Subject: RE: Y/9818/RES and Y/97/18/DOC

Laura Gibbons, MEng, GMICE
Engineer (Drainage & Coastal)

Comments on the revised drainage and landscape proposals:

Job Title		
LAND SOUTH OF BURNDELL ROAD, YAPTON		
Drawing Title		
PRIVATE DRAINAGE CONSTRUCTION DETAILS SHEET 1 OF 2		
Client		
BOVIS HOMES		
Scale	Date	Designed
NTS @ A1	APR 19	SG
Drawn	Checked	Approved
TSB	SG	LH
Job No	Drawing No	Rev
18-070	18-070/110	C

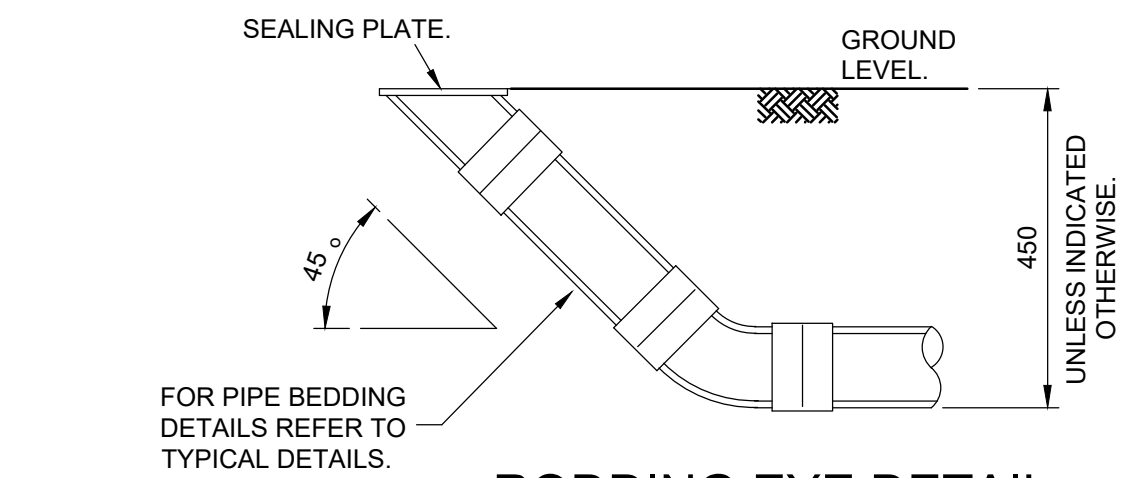
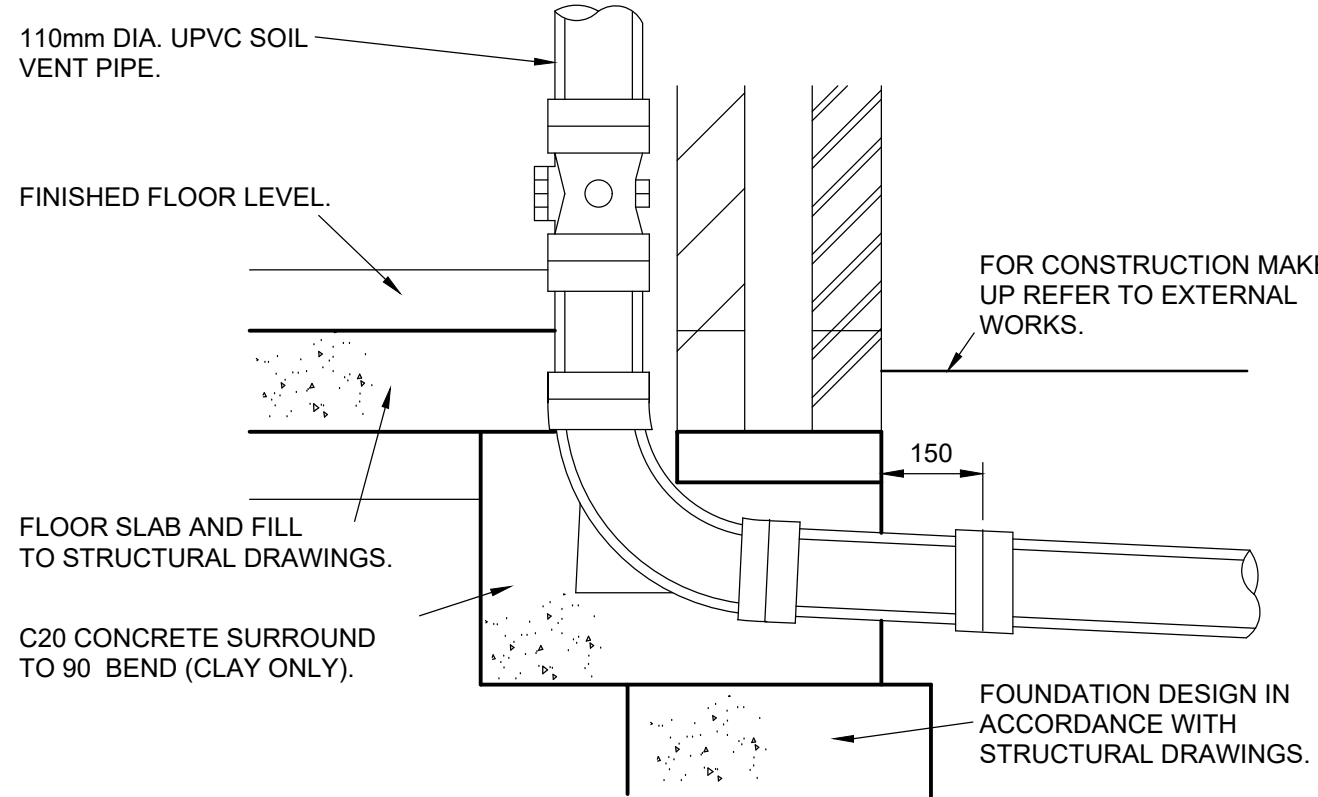
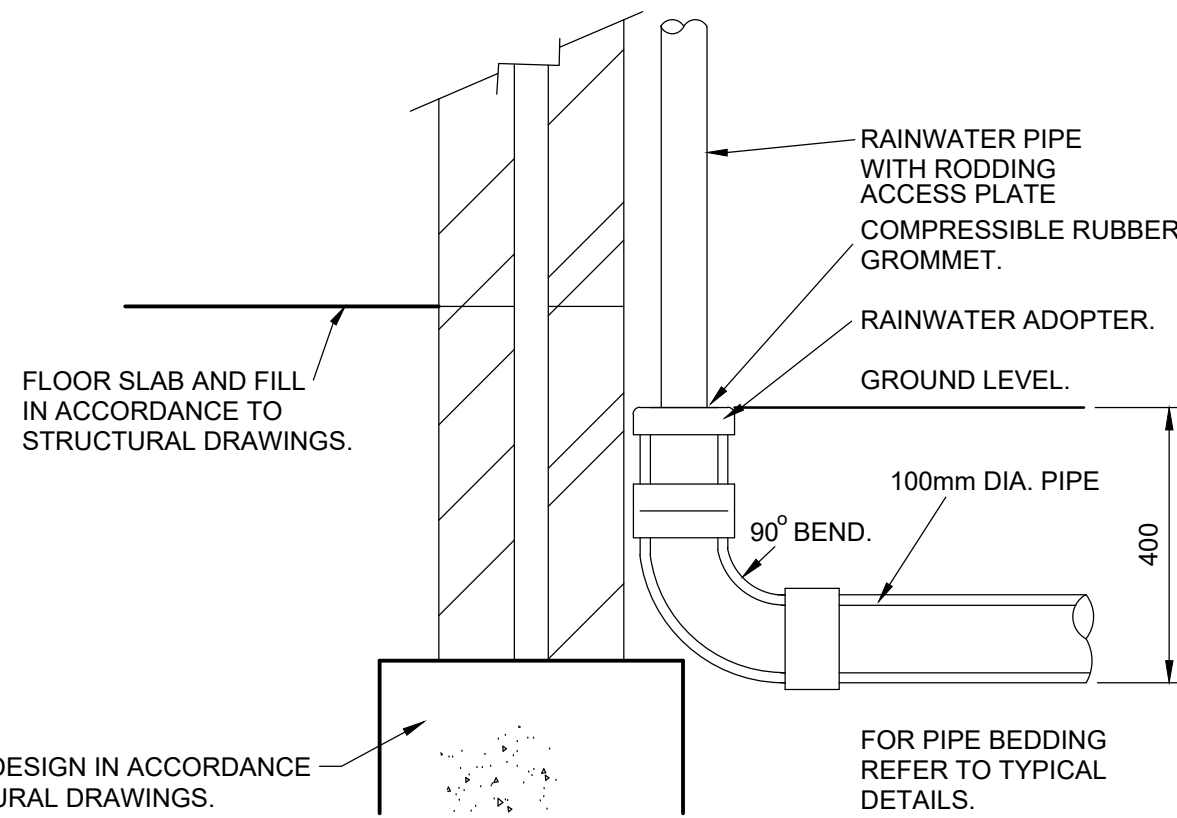
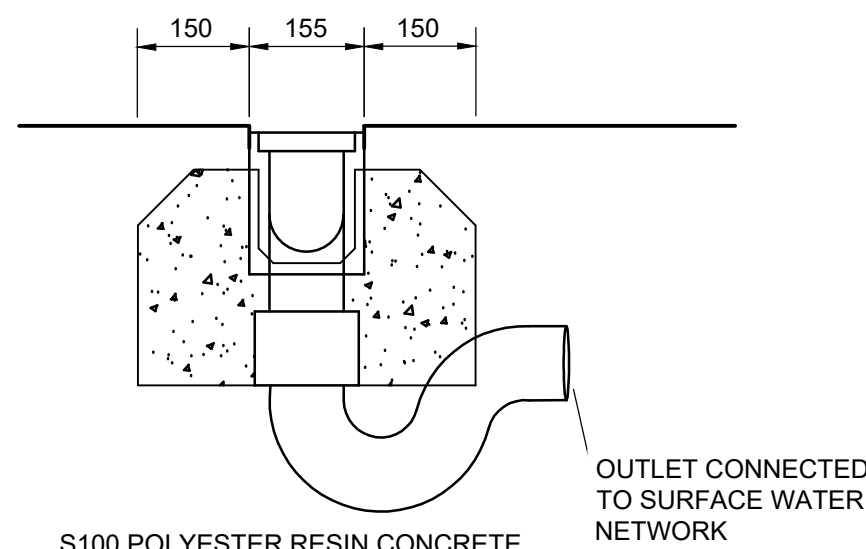
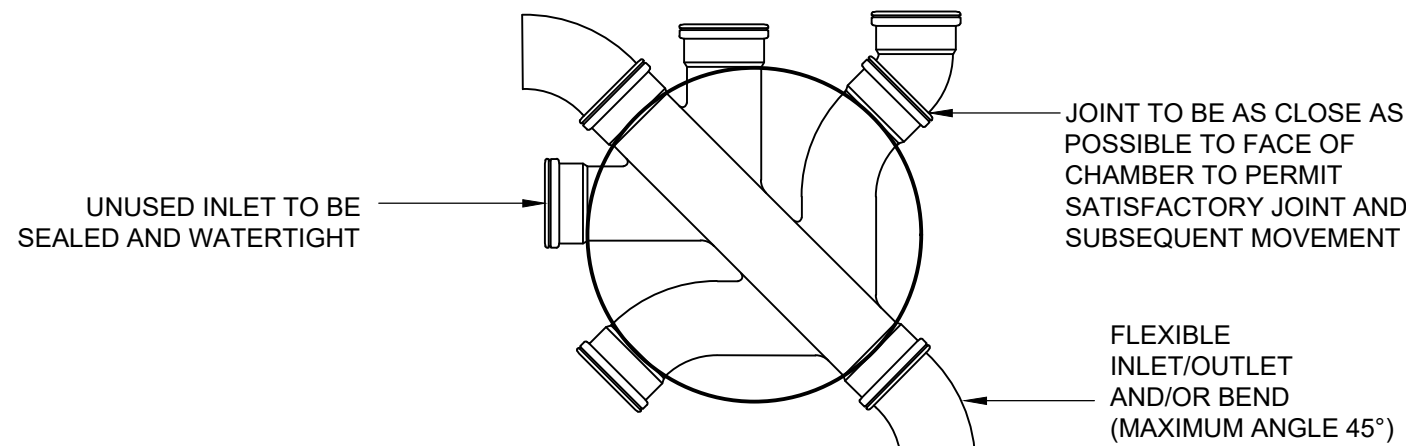
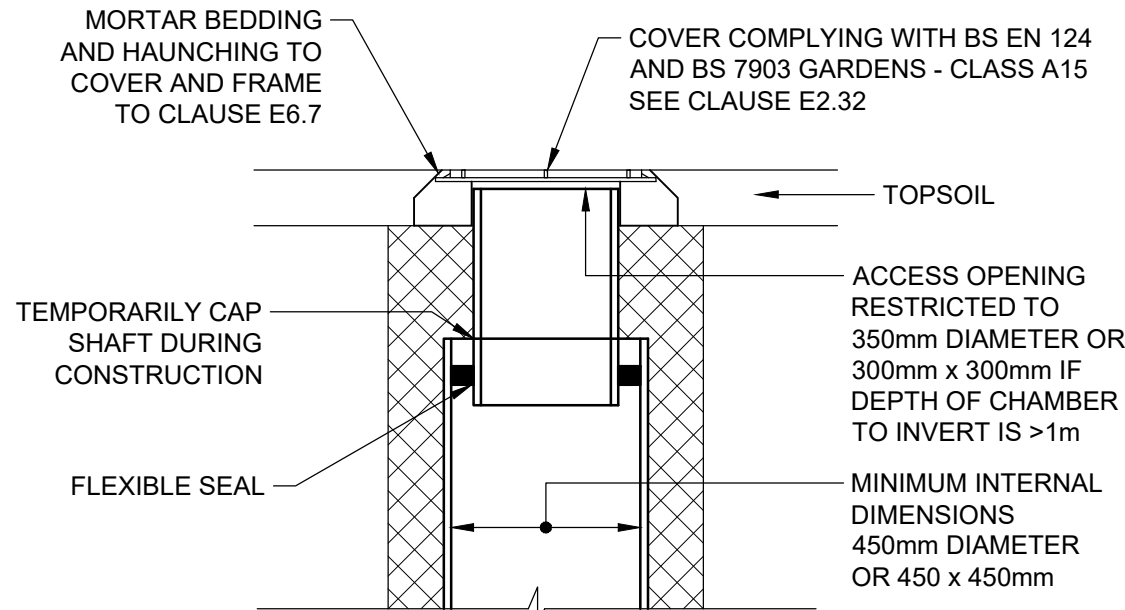
- a. *Construction detail drawings have been provided of diffuser units stating inlet from house, is this what is proposed? It isn't actually clear from the layouts if standard rwp connecting to the main piped network are proposed. There certainly are no diffuser units shown on layouts.*

6. Standard detail updated to show diffuser and control chamber together. Plan updated to show incoming surface water diffusers for typical drive. Permeable paving depths added to drawing (notes). Refer updated plans provided. *To clarify, are you proposing on diffusing rain water from roofs into permeable paving and then connecting the permeable paving to the wider network? You don't actually show control chambers near permeable paving on the layout. Please provide details on layout plans of the connectivity proposed.*
